**WELWYN HATFIELD COUNCIL – DEVELOPMENT CONTROL**  
**DELEGATED REPORT**

<b>APPLICATION No:</b>	<b>S6/2009/1737/FP</b>
------------------------	------------------------

The application seeks full planning permission for the construction of a single storey rear extension with gable roof, in addition to a loft conversion with side dormer and partial front gable extension. The loft conversion which will accommodate 2 additional bedrooms, water closet and ensuite bathroom and includes the construction of an enclosed recessed balcony at the rear of the site, the installation of 3 rooflights in the roof slope of the southern elevation of the property and a side dormer within the roof slope on the northern elevation of the property.

EXISTING  
1:100

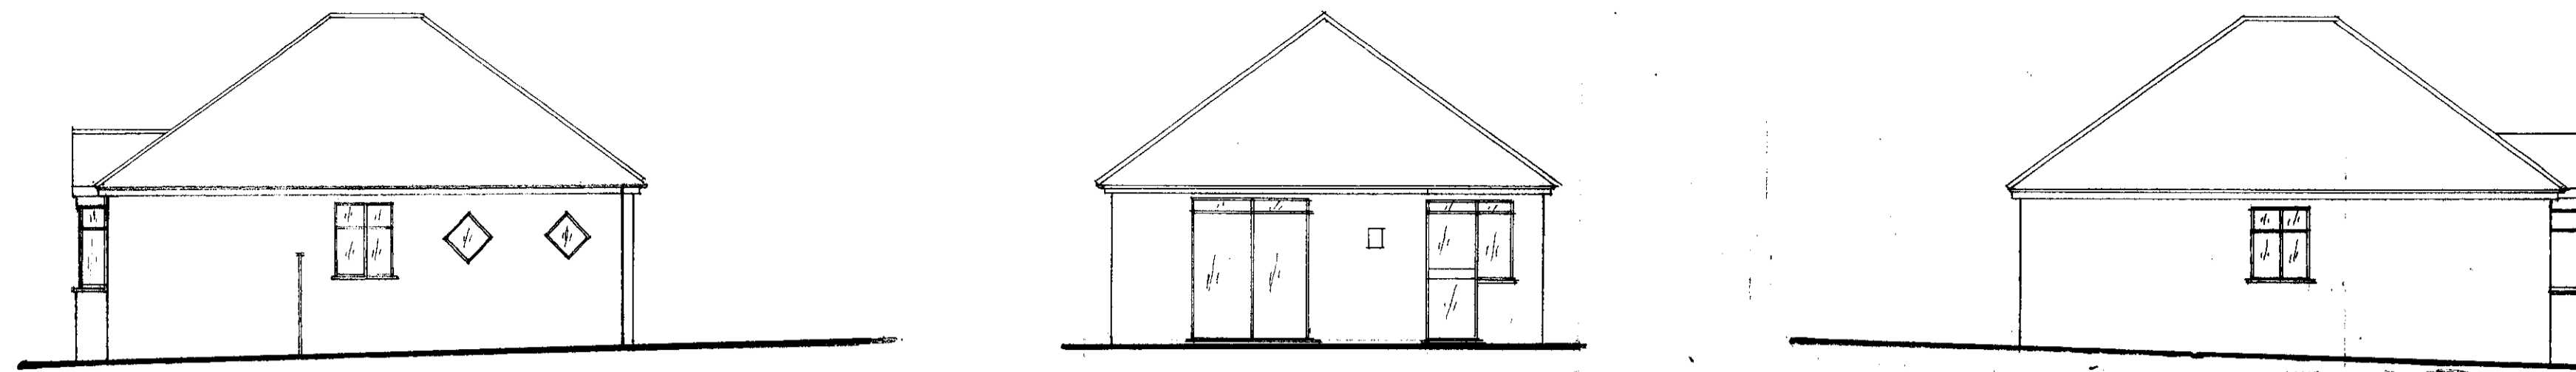
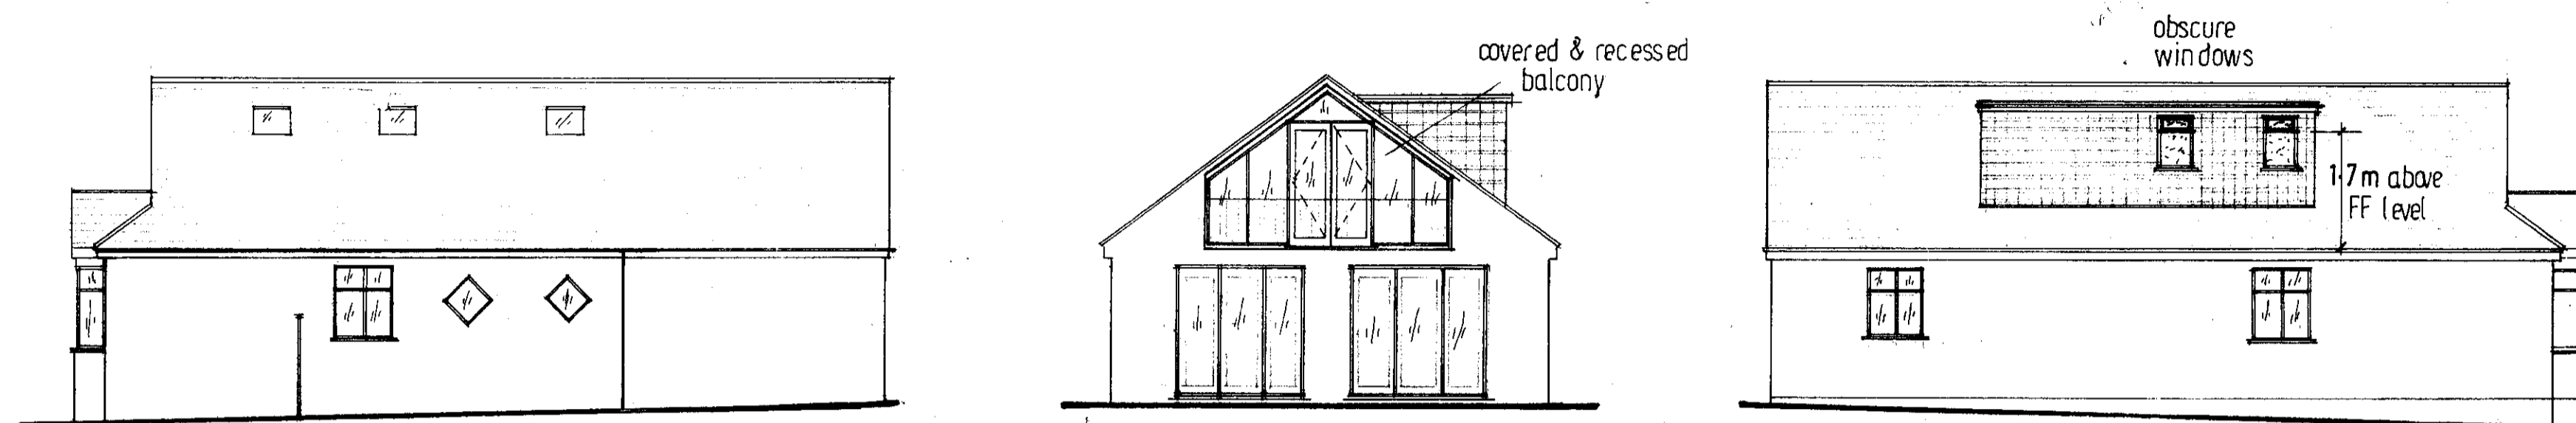
With regards to size, the principle of the loft conversion proposed is considered satisfactory, based on the fact that the majority of the additional floor area will be contained within the roofspace and will not be detectable for the street scene. With regard to design however, the proposed side dormer however does expose the additional floor area within the roofspace and significantly impacts the appearance of the property. The dormer is to be 6m long, 1.7m high, with a width of 2.8m and is set almost within the middle of the roofslope and results in a visually dominant addition to the property impacting upon the character of the area.

The character of some areas of Cuffley have changed over time, with side dormers permitted. In the circumstances of this case however, it is apparent that the immediate area surrounding the property in South Drive however does not have any side dormer additions and has maintained some of the original character. Therefore it is considered that the proposed side dormer would be contrary to the maintained character of the area and as a result would reflect poorly on the property and form a visually incongruous form of development.

In addition, the loft conversion and front gable is considered to be satisfactory in principle as it compliments and does not detract from the architectural integrity of the building. The side dormer window however is considered to dominate the with northern elevation of the property and appear visually incongruous on the front

façade of the property and therefore is not in keeping with the style of dwellings within the immediate area contrary to Policies D1 and D2 of Council's Supplementary Design Guidance.

1. The proposed side dormer by virtue of its bulk and design would neither compliment nor reflect the character and design of the existing dwelling or that of the context of the area. The resultant structure would therefore be an incongruous form of development to the detriment to the visual amenities of the street scene. The proposal is therefore considered to be contrary to policies D1 and D2 of Welwyn Hatfield District Plan 2005, ENV7: Quality of Design and Planning Policy Statement 1: Delivering Sustainable Development.

NEW LOFT PLAN 1:50

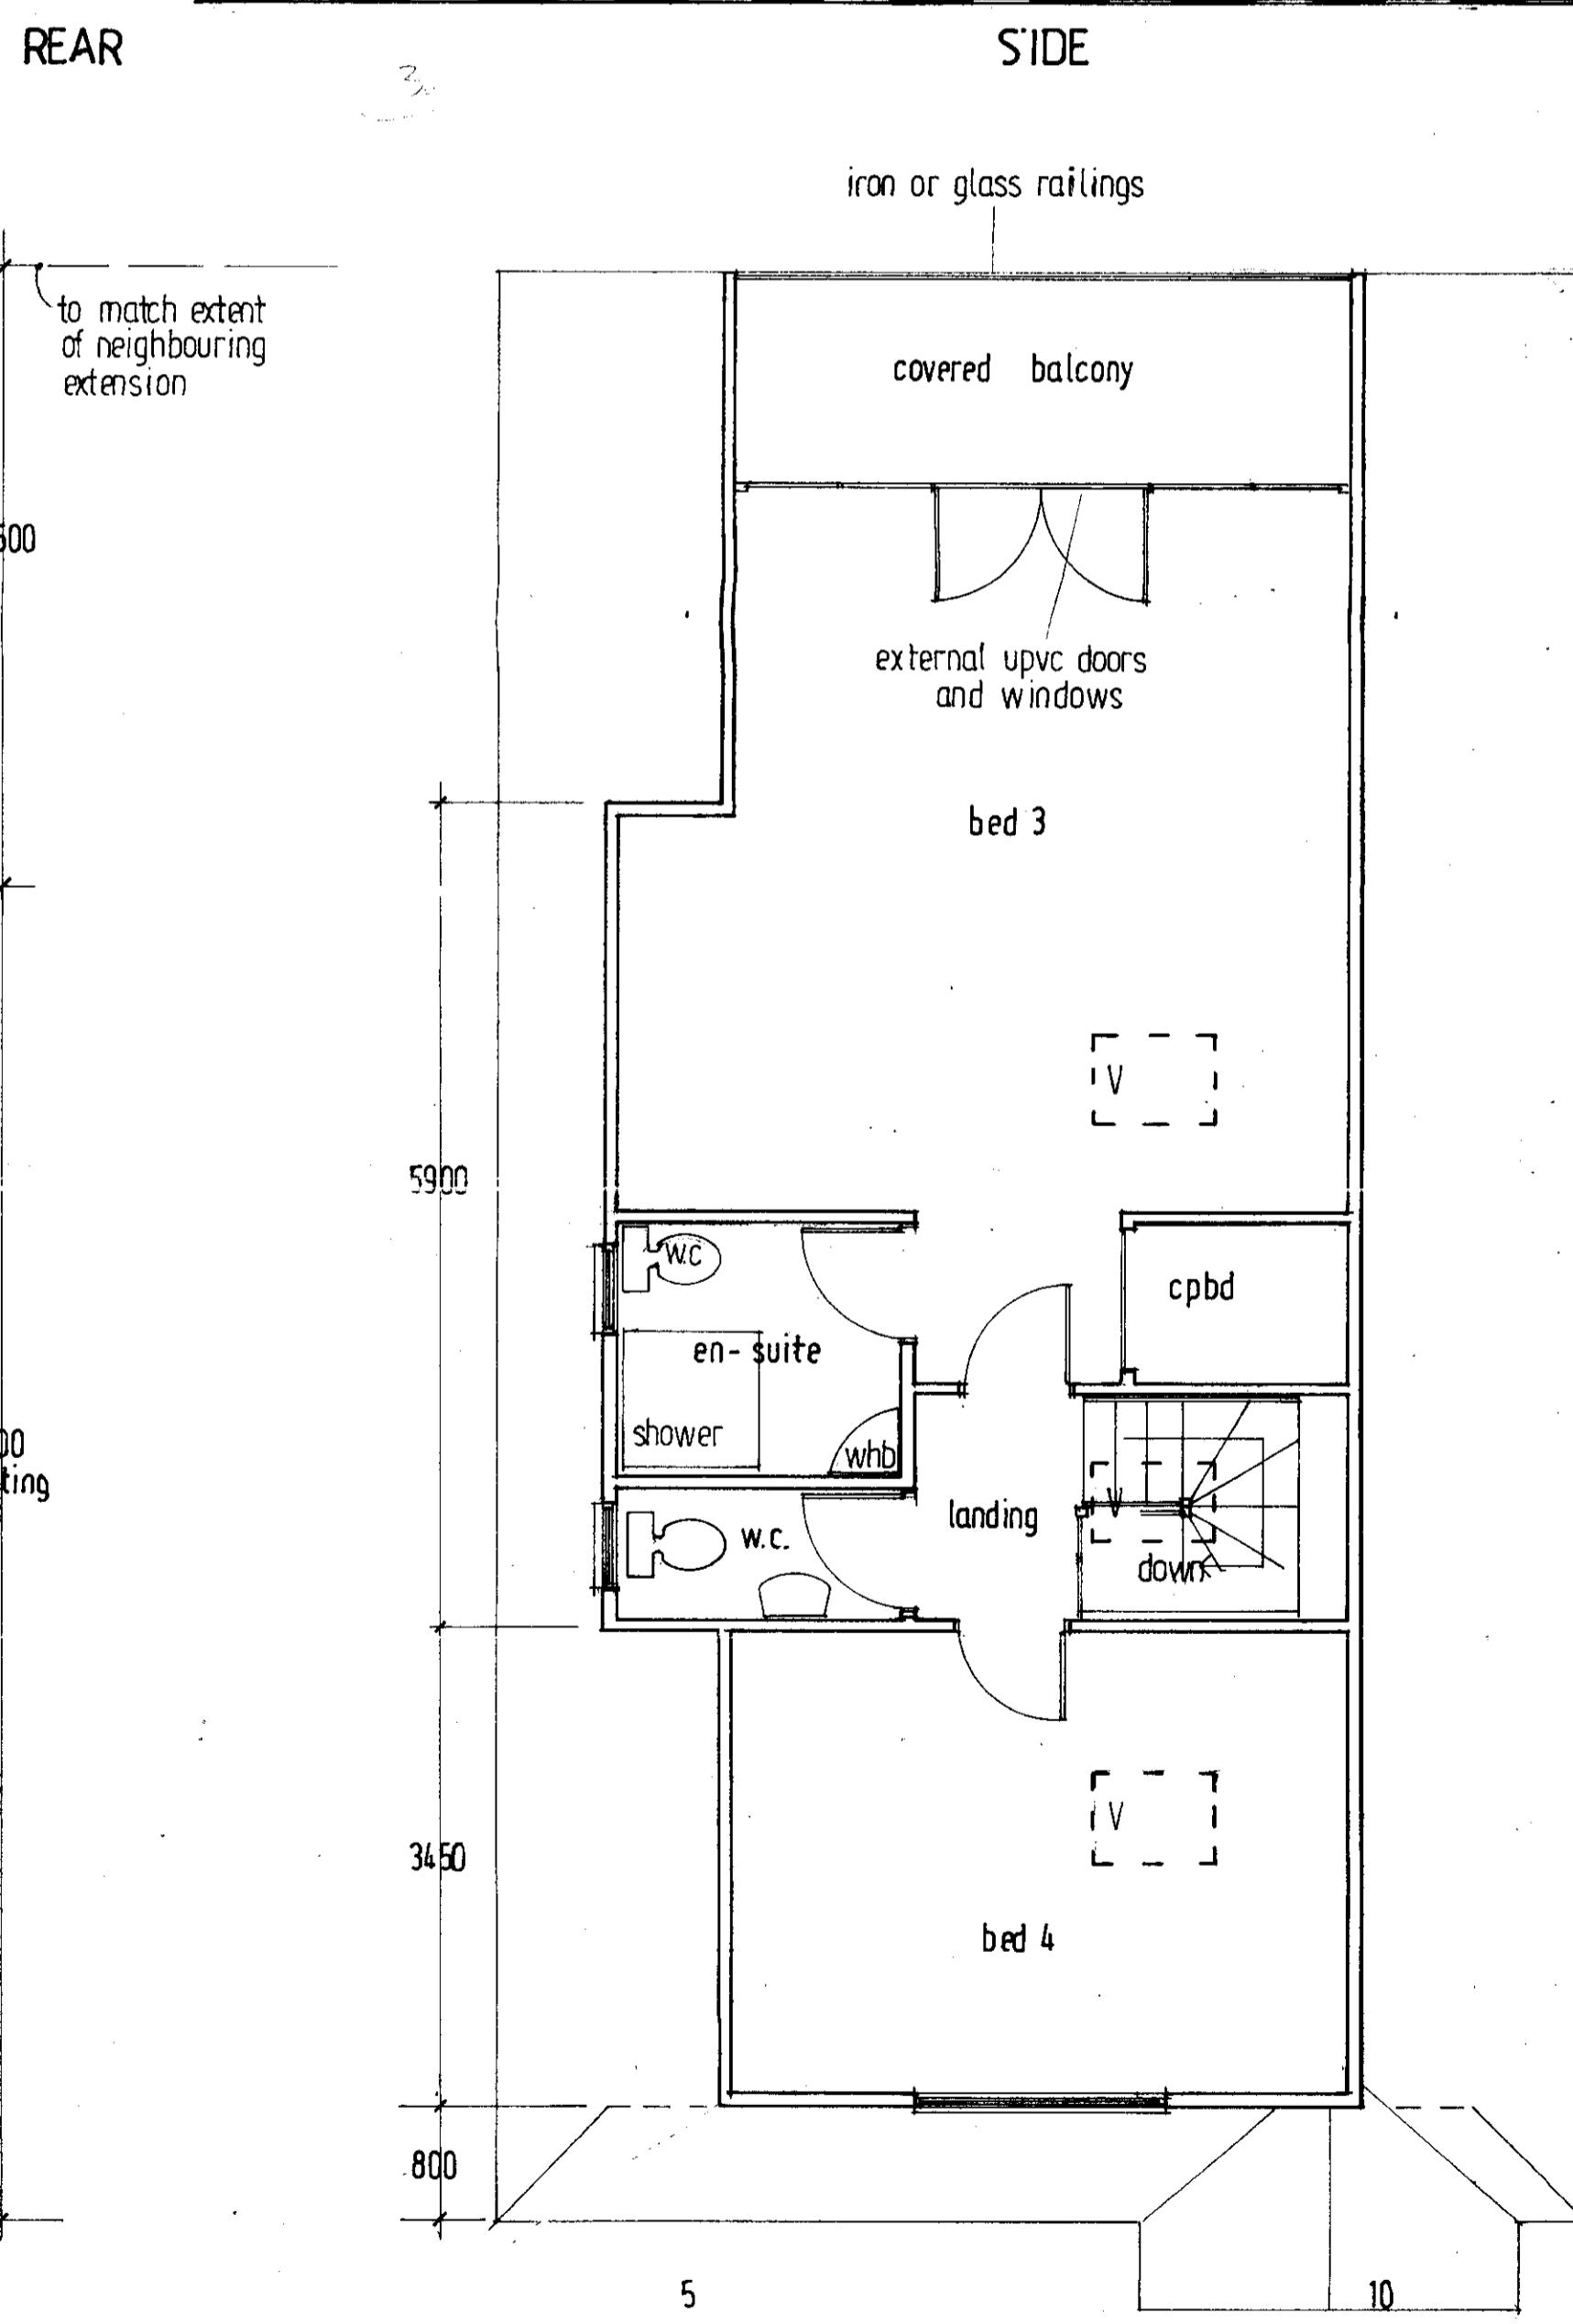
Objection has been raised by the Parish Council and adjoining property regarding privacy and overlooking issues from the proposed balcony at the rear of the property. The balcony however is to be covered and recessed, therefore persons standing on the balcony will not be able to see into the gardens of the adjoining northern and southern properties. The elevation plans show that the view from the properties will be of the roof of the extension only. It is therefore considered that privacy between the properties is maintained. Overall it is considered that the amenity of the adjoining properties is maintained to an acceptable level and does not warrant refusal of the application.

BLOCK PLAN  
1:500

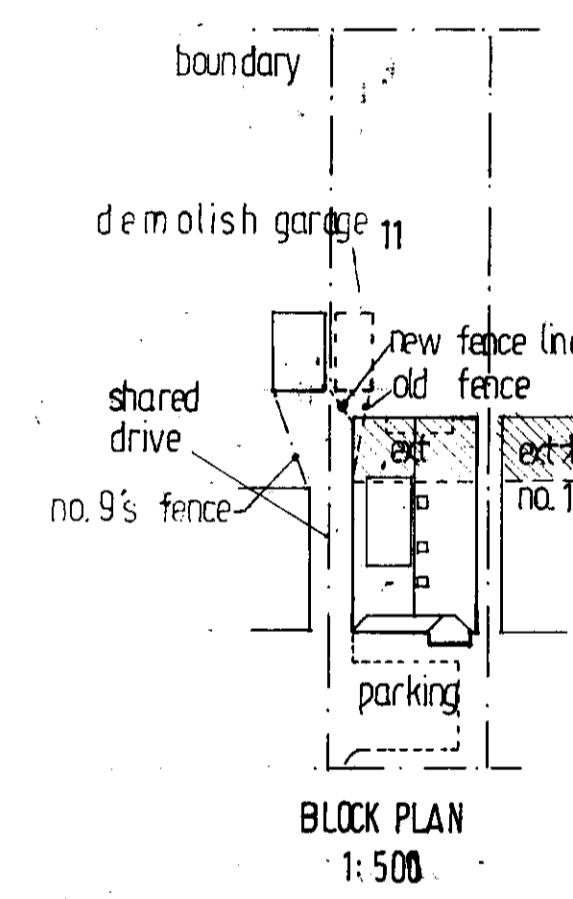
3. The proposal involves the removal of the garage at the rear of the property to accommodate the rear extension. A hard paved area within the front garden of the site is proposed to accommodate parking 5.5m x 7m, this area however will only accommodate 2 parking spaces. The adopted parking standards (supplementary planning guidance) specify that the maximum parking requirement for dwellings in this location (Zone 4) is 3 spaces for a 4 or more bedroom property. In aesthetic terms, the proposal to hard pave a large majority of the property is not desirable, however this type of arrangement appears to be common within the street, and therefore in this case is considered satisfactory subject to further embellishment of soft landscaping within the front. Despite this, given that only 2 parking spaces are provided, the proposal fails to demonstrate adequate car parking in accordance with the requirements of policy M14 and the Supplementary Planning Guidance for Parking Standards 2004.

2. The proposal by virtue of the loss of the existing garage parking space would result in the dwelling only having only two on site parking spaces rather than the required three for a four bedroom property. The proposal would therefore be contrary to policy M14 of the Welwyn Hatfield District Plan 2005 and the Welwyn Hatfield District Plan Supplementary Planning Guidance for Parking Standards 2004.
